Please find attached the London Borough of Havering (20025659) submission for Deadline 5 for the M25/J28 Improvement Scheme (TR010029). This submission concerns LB Havering's response to further Written Questions that were published on 25th March (PD-015).

Application by Highways England for the M25 Junction 28 Project

The Examining Authority's Further Written Questions and requests for information (WQ2)

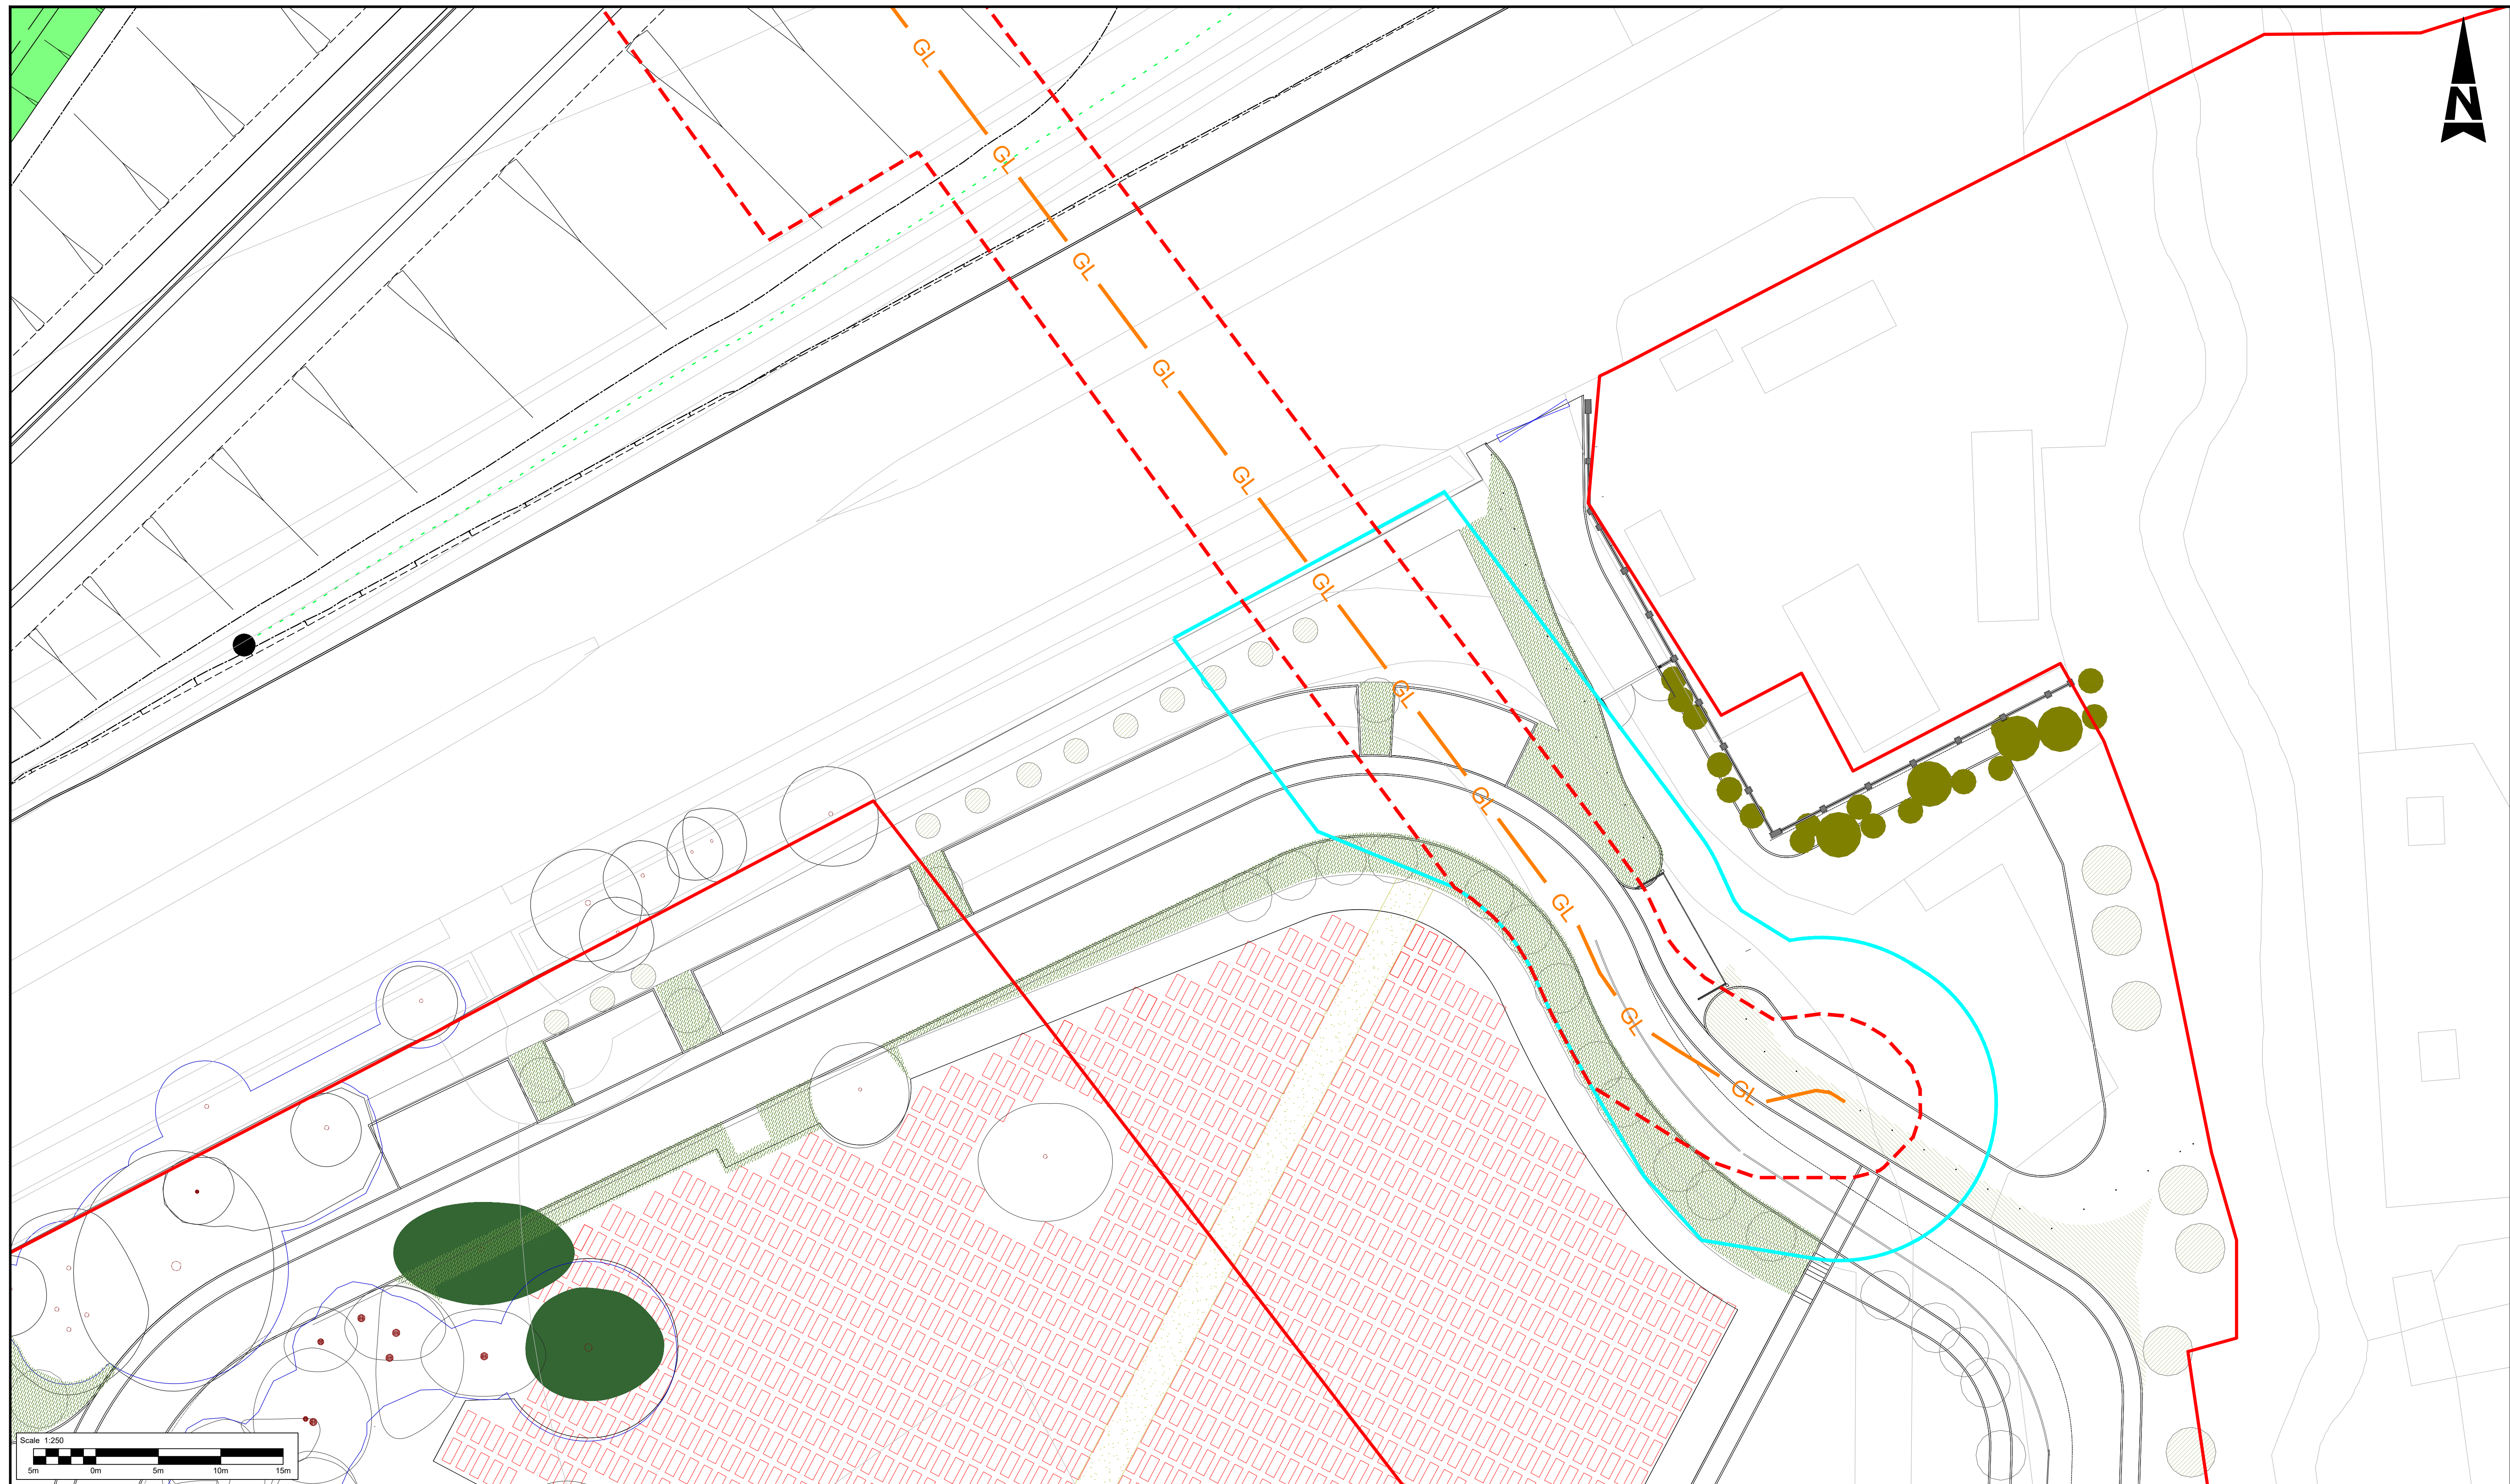
CA 2.3	<p><i>Plot 1/8</i></p> <p>The Applicant</p> <p>Gardens of Peace Muslim Cemetery</p>	<p>Following a request to do as Action Point 5 [REP4-018], the Applicant submitted a Gardens of Peace Muslim Cemetery Overlay Plan at Deadline 4 [REP4-020] in which it is demonstrated that Plot 1/8 would not extend over the burial plots.</p> <p><u>For the Applicant:</u></p> <p>i) Explain how this plan is secured in the draft DCO [REP4-002] as a certified document and whether it forms would form part of the Land plans [REP3A-003].</p> <p><u>For the Gardens of Peace Muslim Cemetery:</u></p> <p>ii) Respond to the Gardens of Peace Muslim Cemetery Overlay Plan submitted at Deadline 4 [REP4-020].</p>	<p>LB Havering notes the submission by the Applicant at Deadline 4 of REP4-018.</p> <p>LB Havering awaits confirmation of the views of the Gardens of Peace Cemetery and will update the ExA with regards to the Policy Compliance matter Havering has previously raised relating to the potential loss of burial plots, accordingly.</p>
